Subject: doc 2026/90507 at location land adj, 21, Westcliffe Rise, Cleckheaton, BD19 5HX

This is to review the discharge of condition 4 of 2025/91577:

Condition 4 – bats and bird boxes

Drawing Title  
 HOUSING

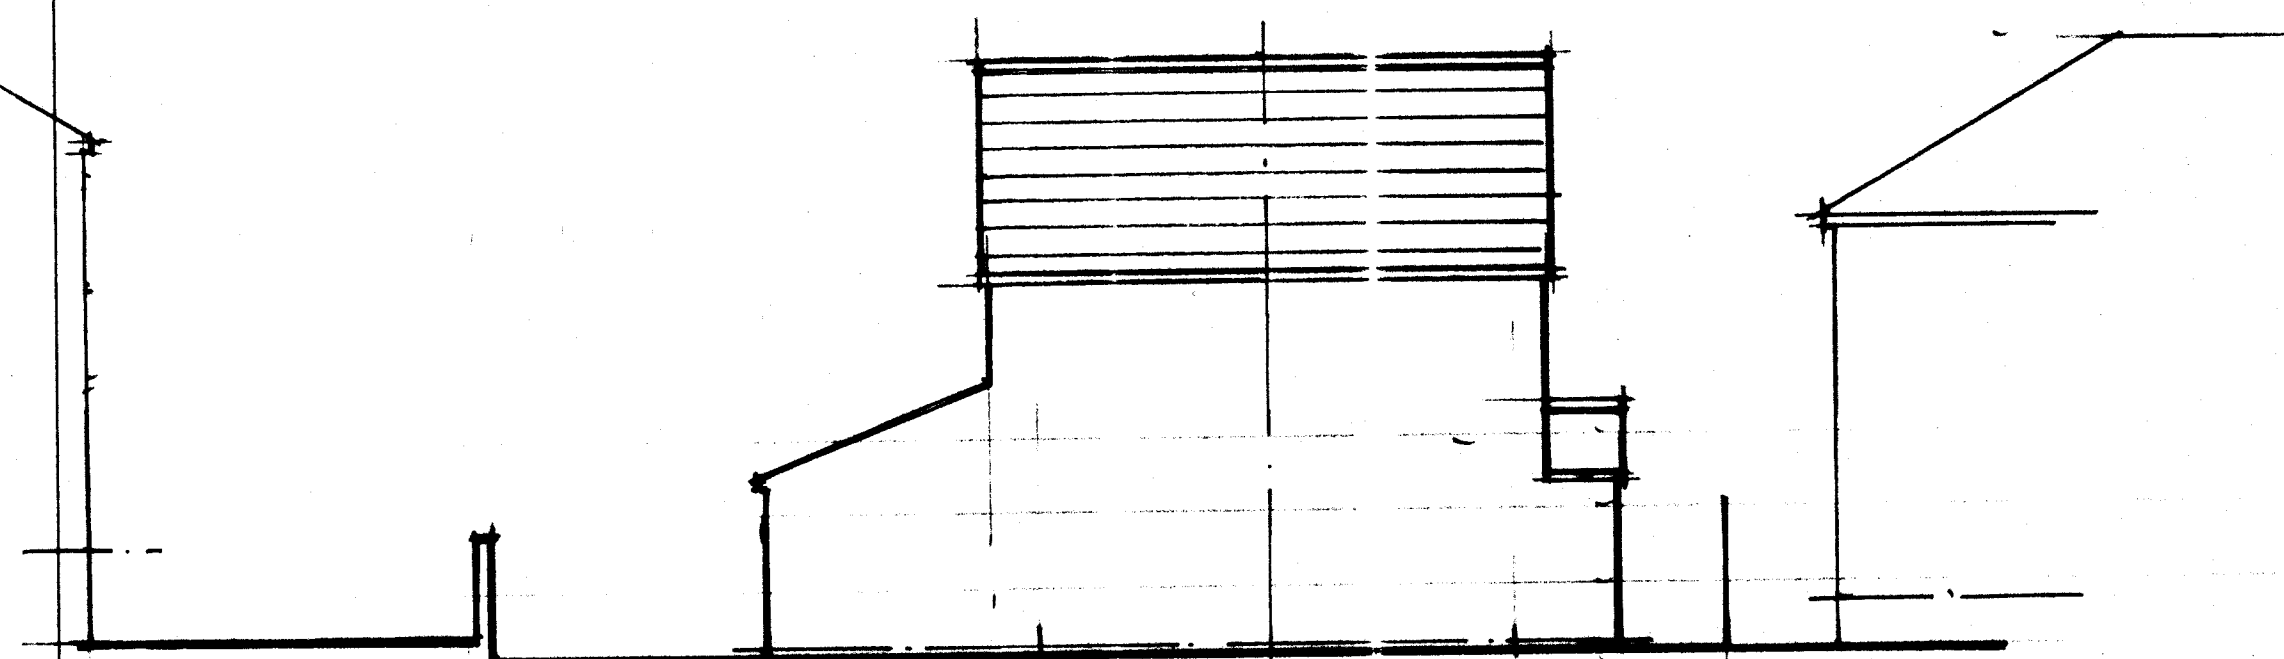
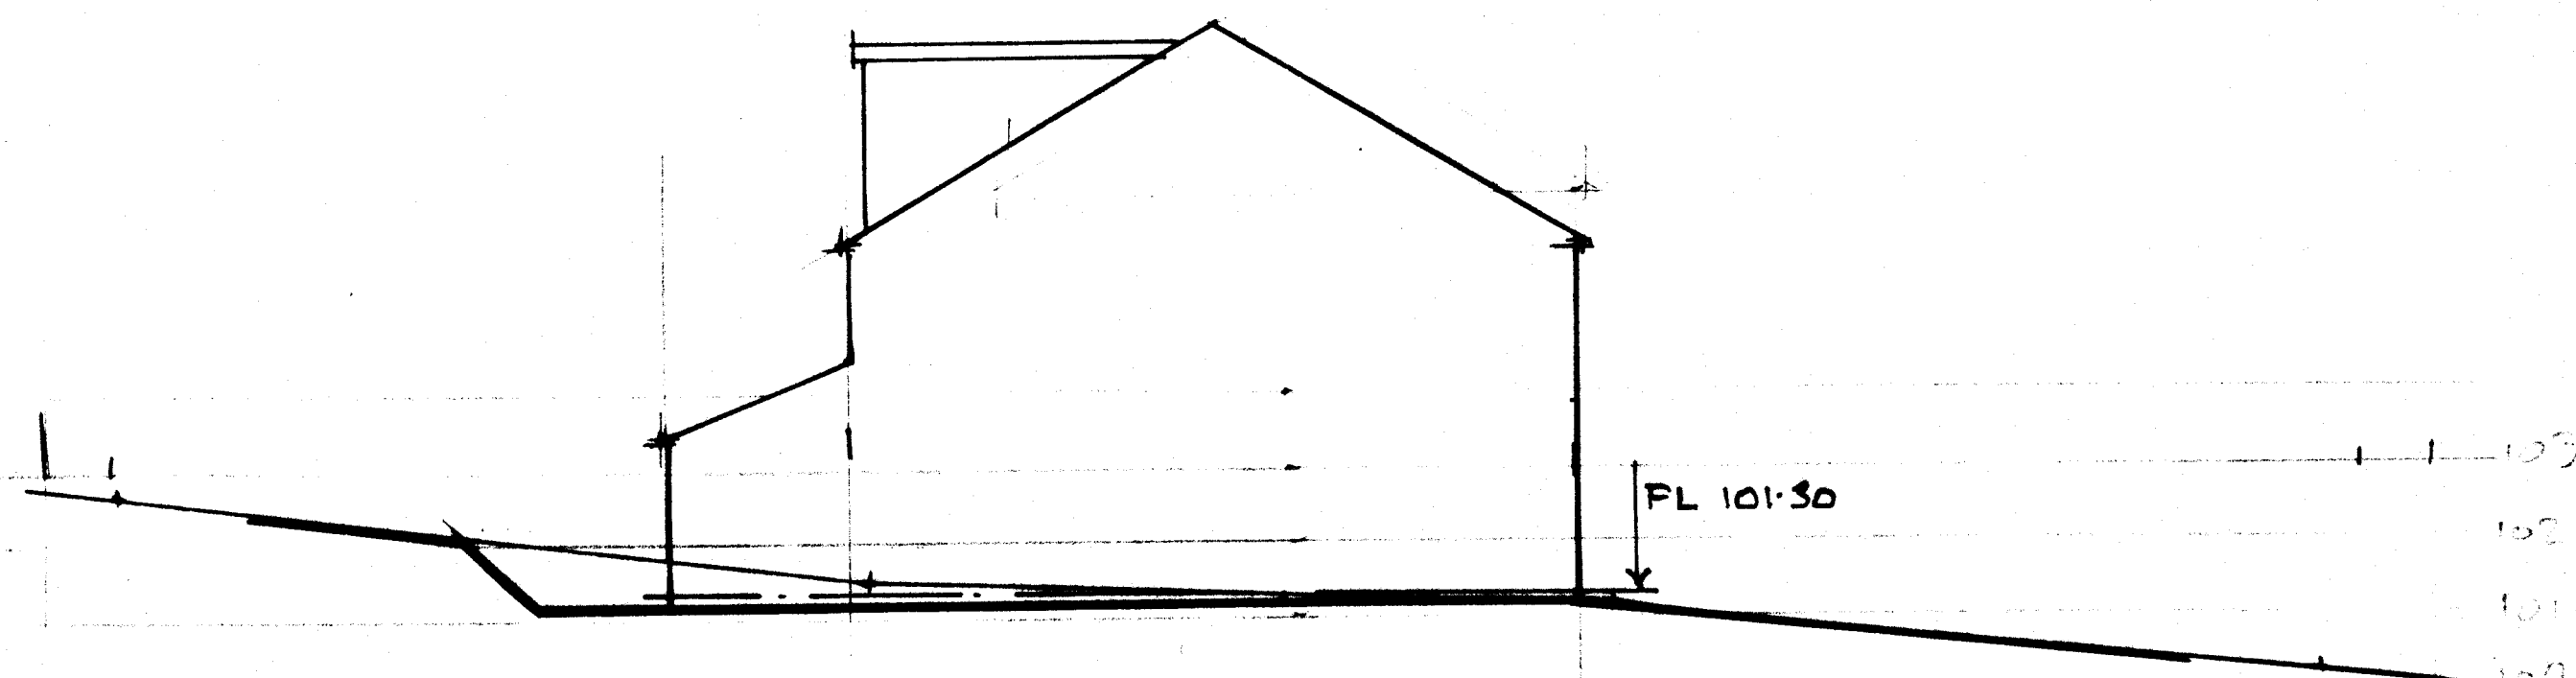
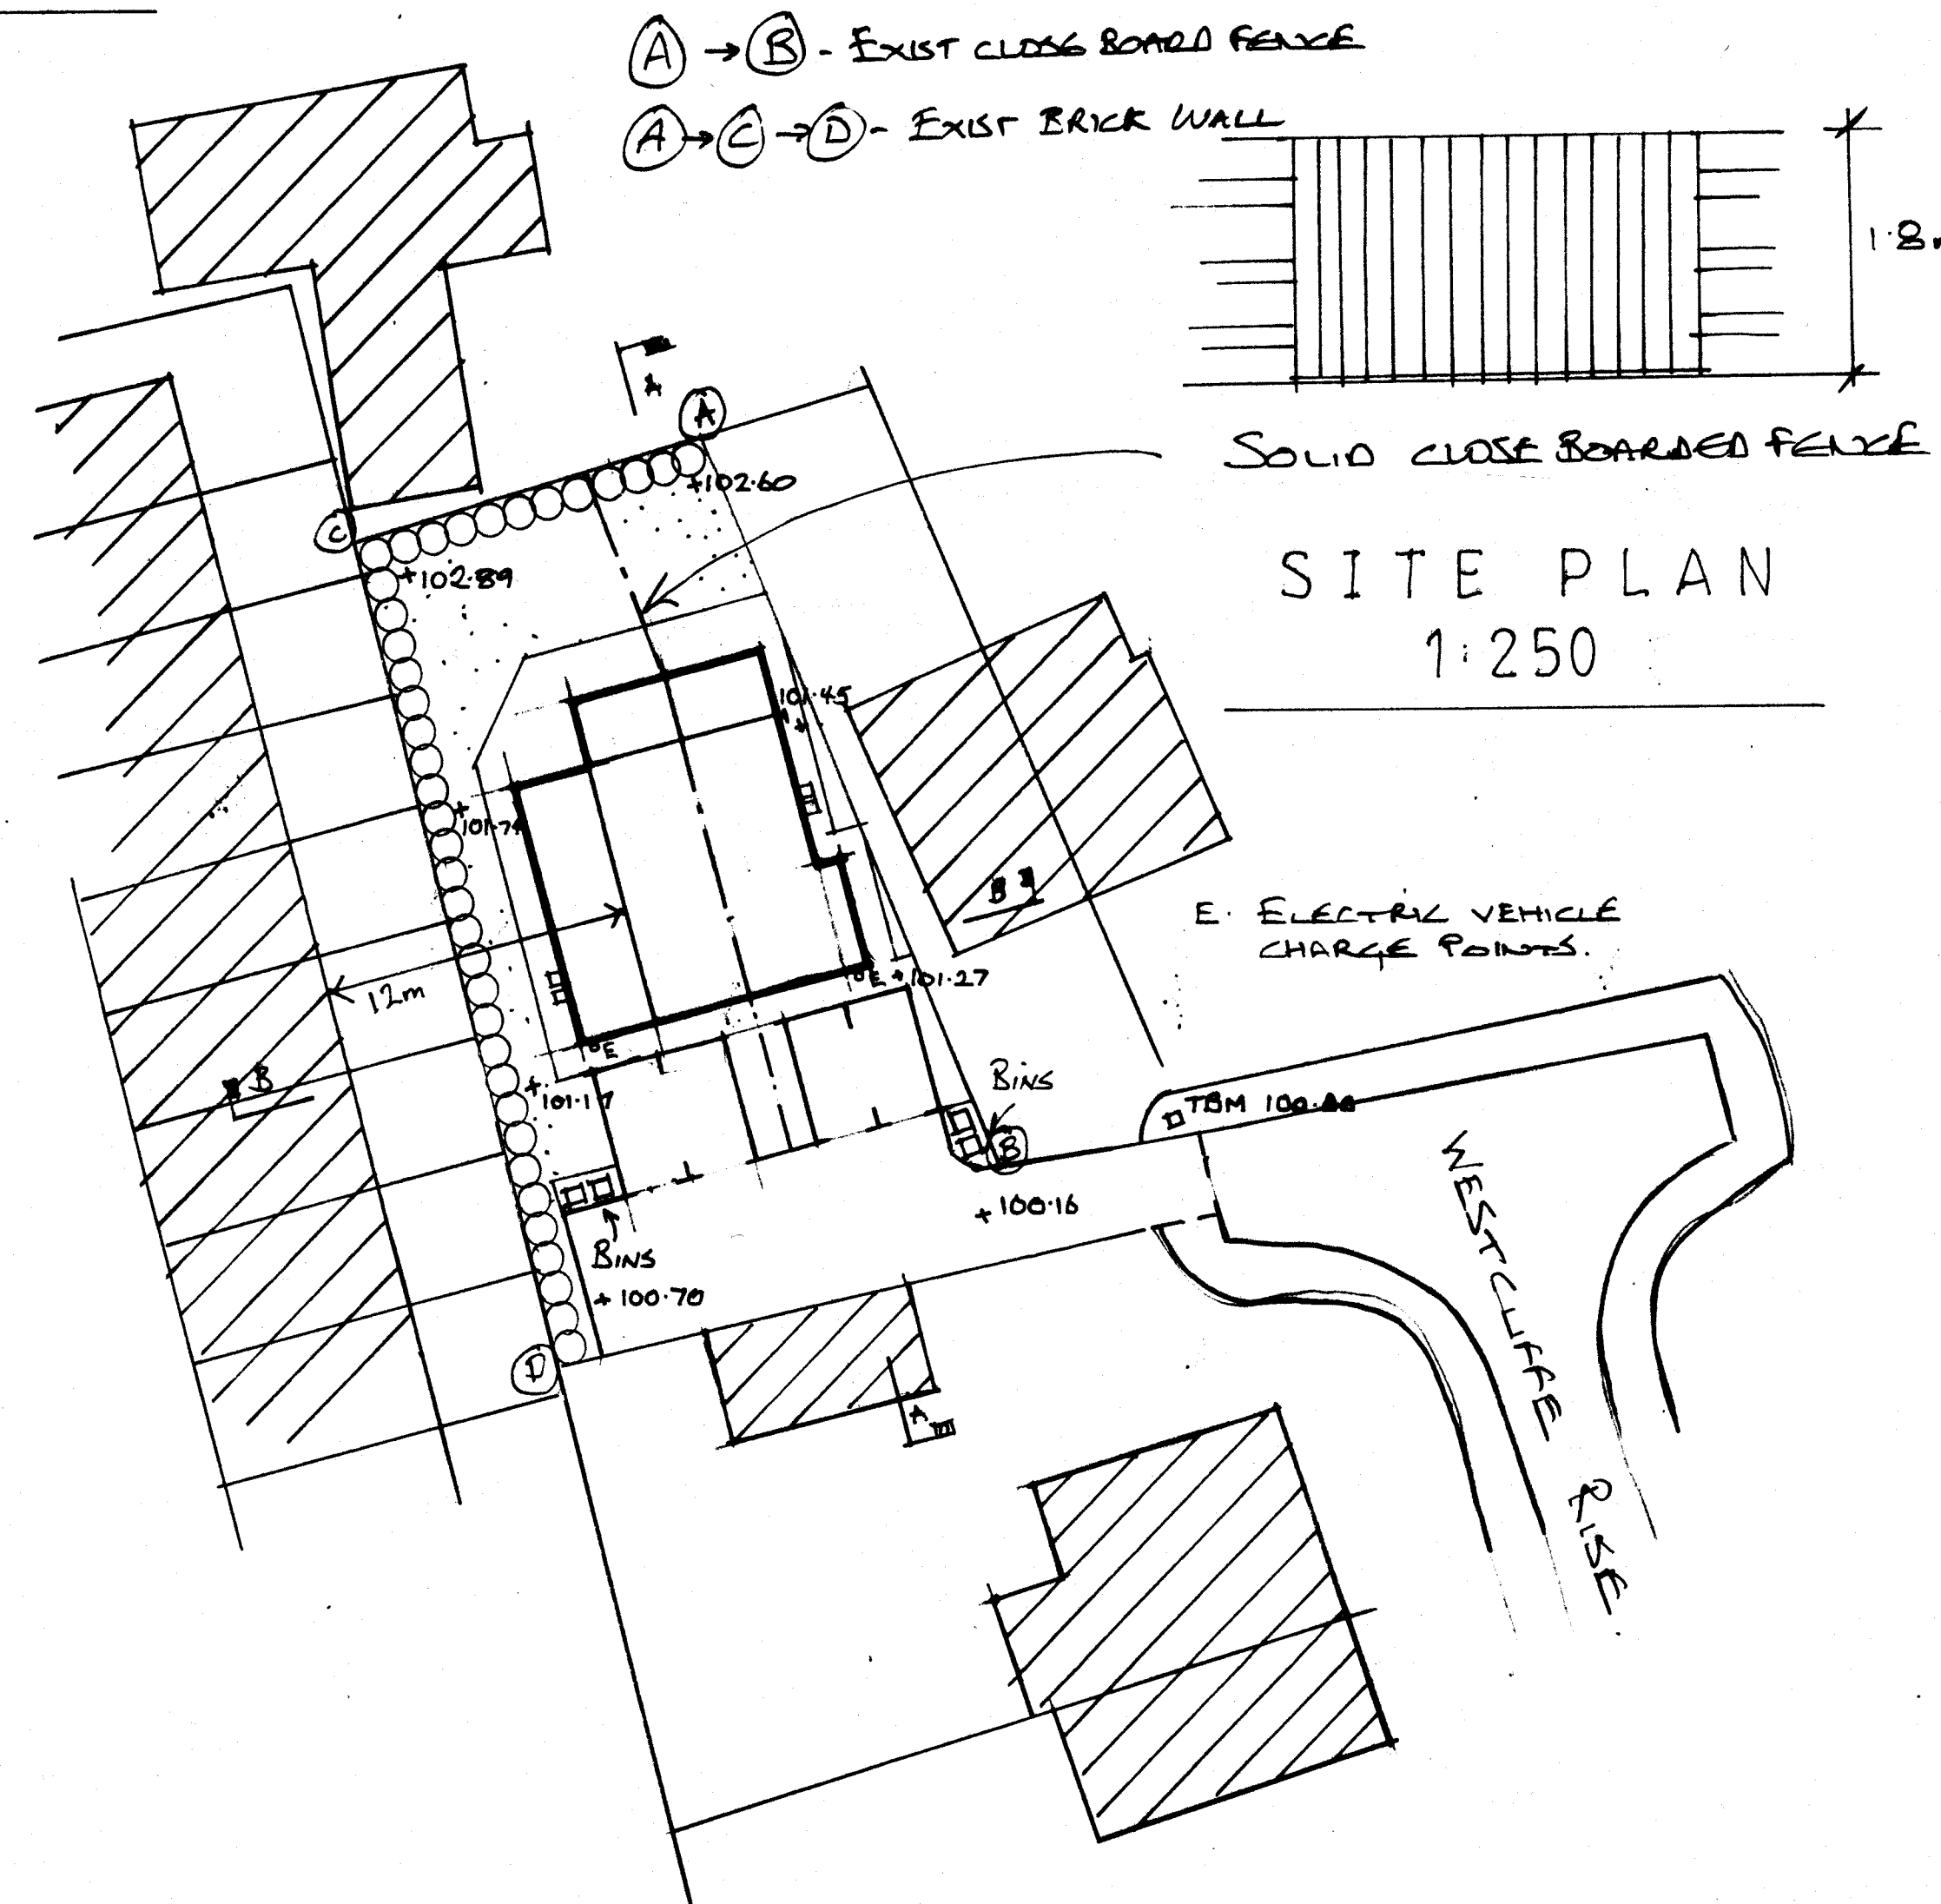
The “Housing” drawings provided by JA Oldroyd and Sons Ltd (June, 2025) has been reviewed and does show (in handwriting) that bat and bird boxes will be installed and their locations on the new structure. This is in line with the requirements of the condition.

Condition 4 is met.
